**From:**  
**Sent:** 24 August 2020 22:57  
**To:** Kate Mansell <Kate.Mansell@kirklees.gov.uk>  
**Subject:** RE: 2020/92546 Black Cat

As a long standing resident of Matlock House I feel the need to comment on the Urban sprawl proposed by the EK group.

Z:\projects\1852 Former Fireworks Factory, Huddersfield\CAD\Croft Drawings\1852-F01-F02.dwg

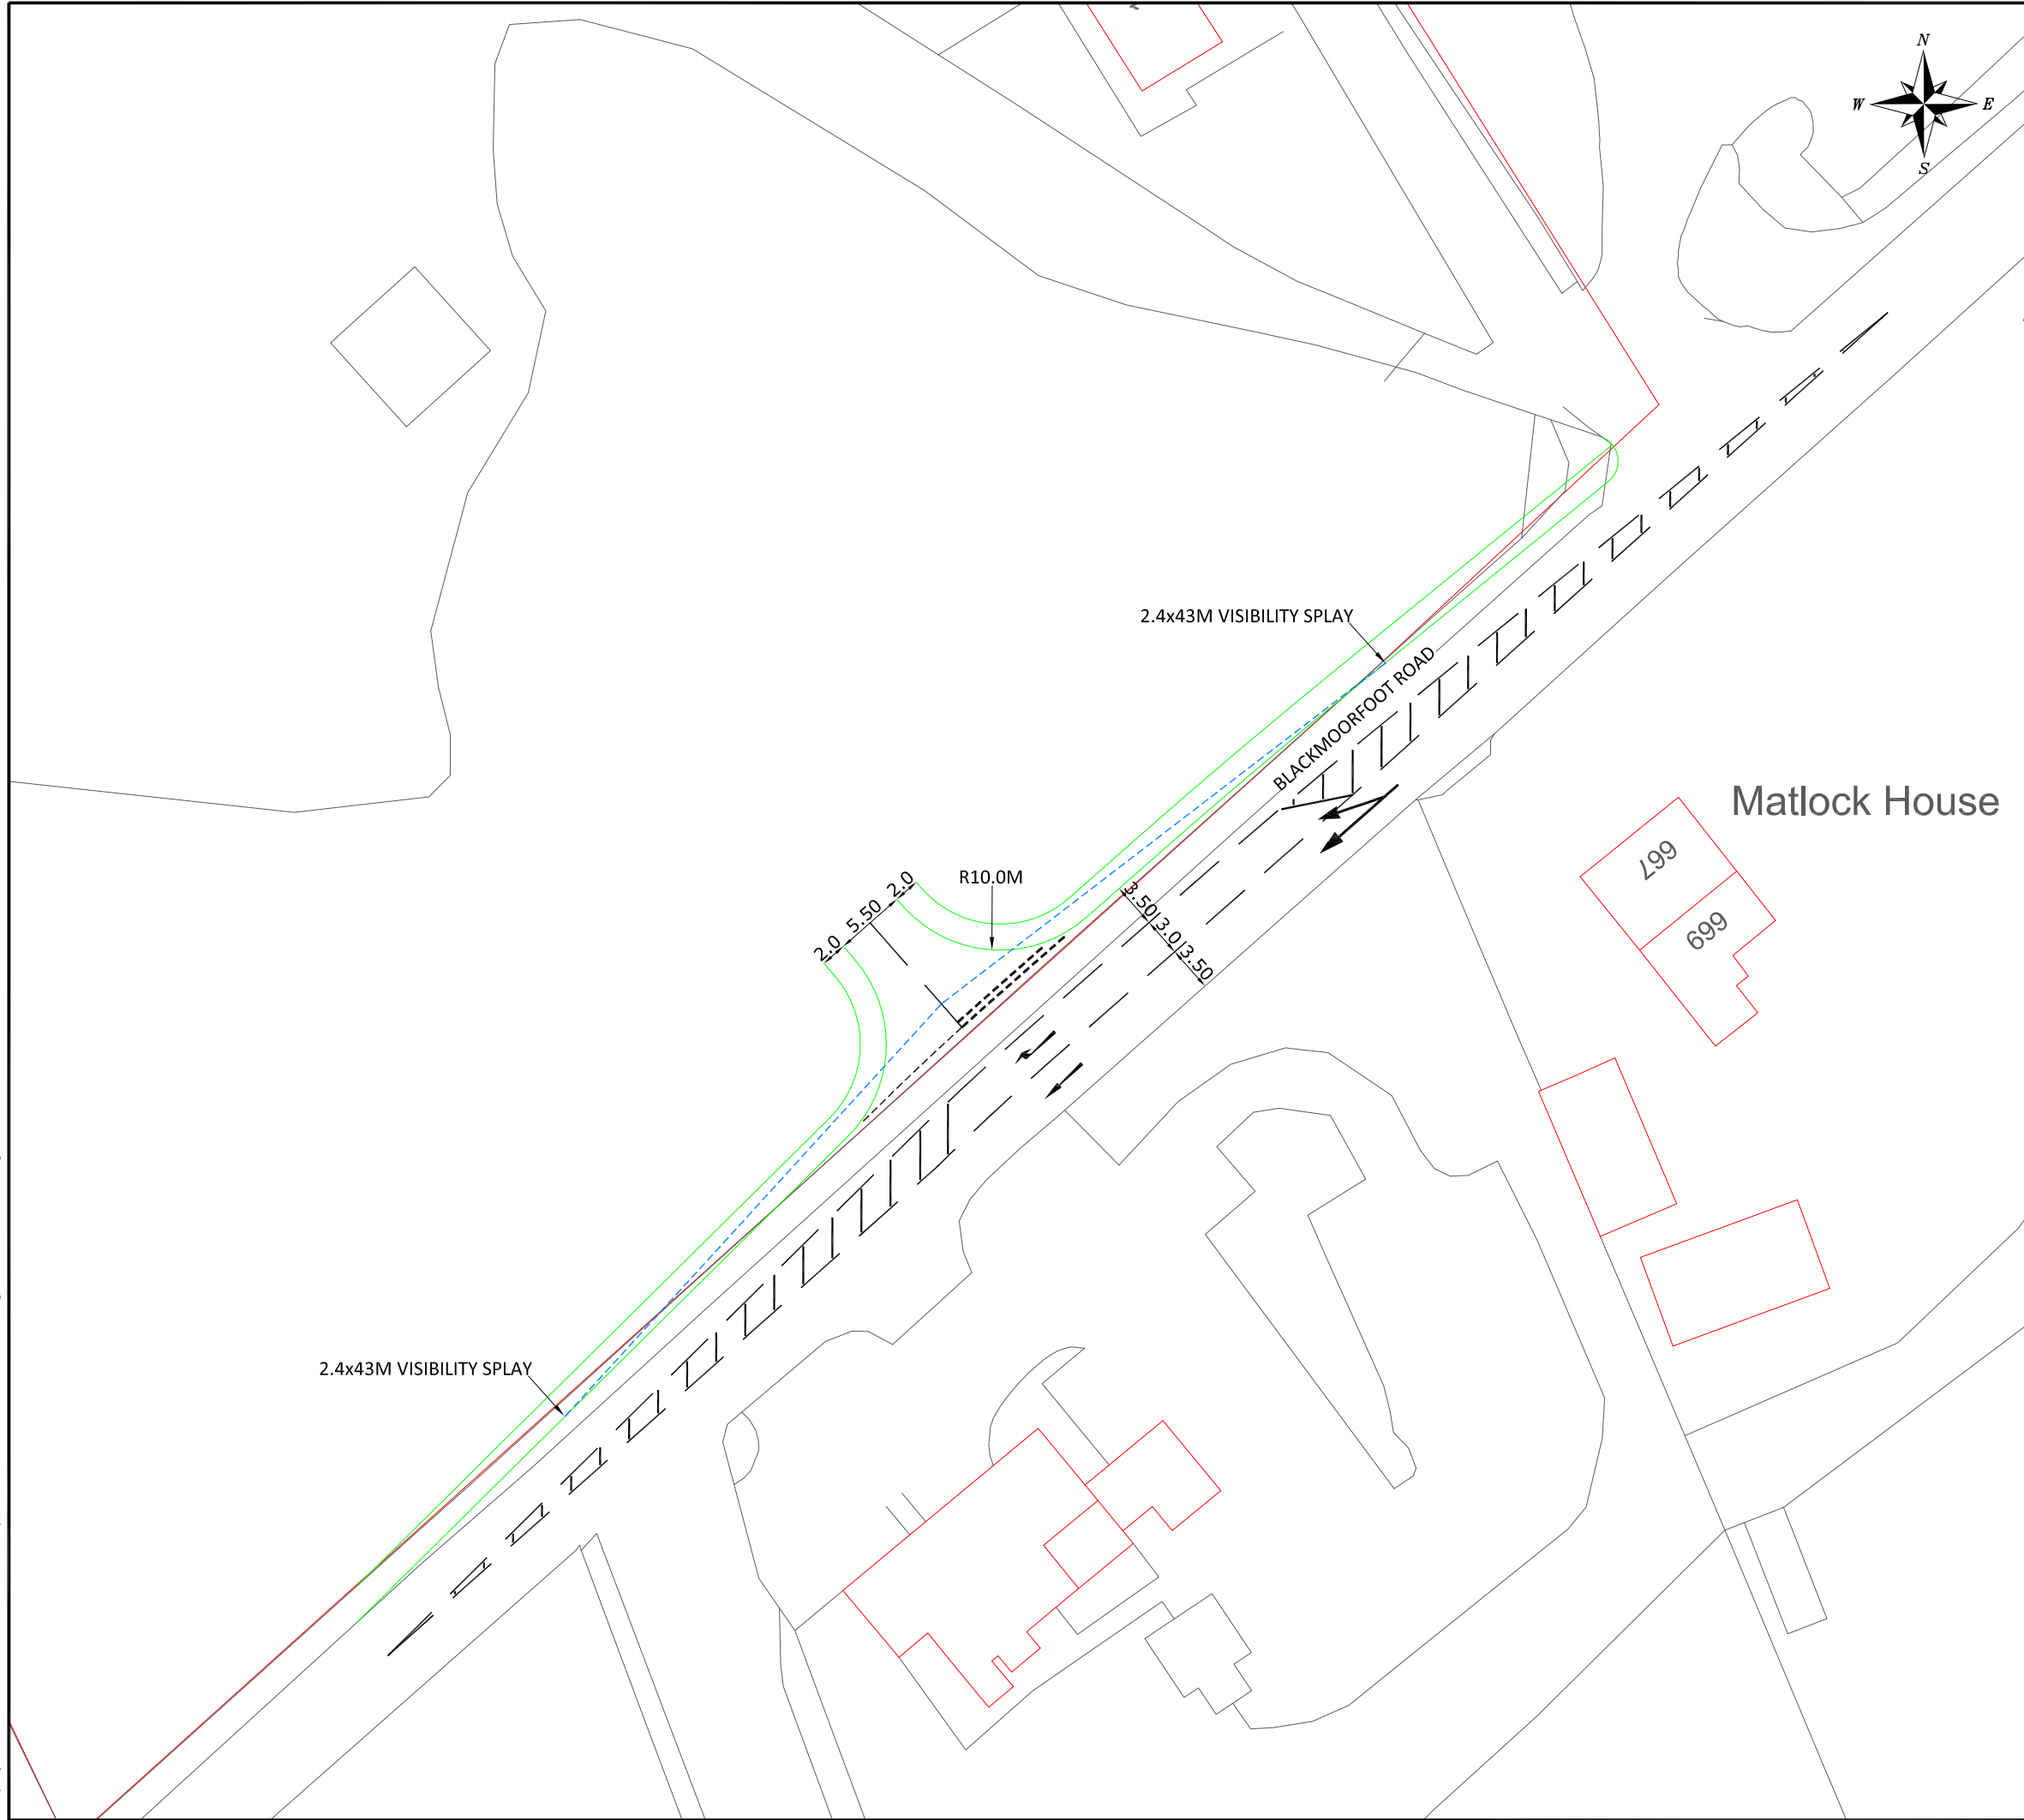
I suggested that a project of this magnitude given its relative rural location and the main road it is going to be linked to would essentially benefit from a roundabout which would incorporate the sands house lane junction and would not result in any land being C.P'd as it would be partially onto the black cat land ,but I was informed that the decision was already made to have a run off lane coming down the road and a right turn lane coming up Blackmoorfoot Road.

My concern is that the applicant provide a more suitable method of entrance to the site as given the nature of the road when viewed from the Crosland hill road junction it is understandable why people insist on breaking the speed limit not just by a small margin but by a considerable amount with some passing my house whilst overtaking and still on the wrong side passing the sands house lane junction.

I could go on but again my main concern that whilst I accept this development will proceed it is imperative substantial traffic calming measures are in place to ensure safe entry and exit to and from the site and re- siting of the proposed entrance as it is going to result a concentration of exit and entry points in a very short distance 5 in total .
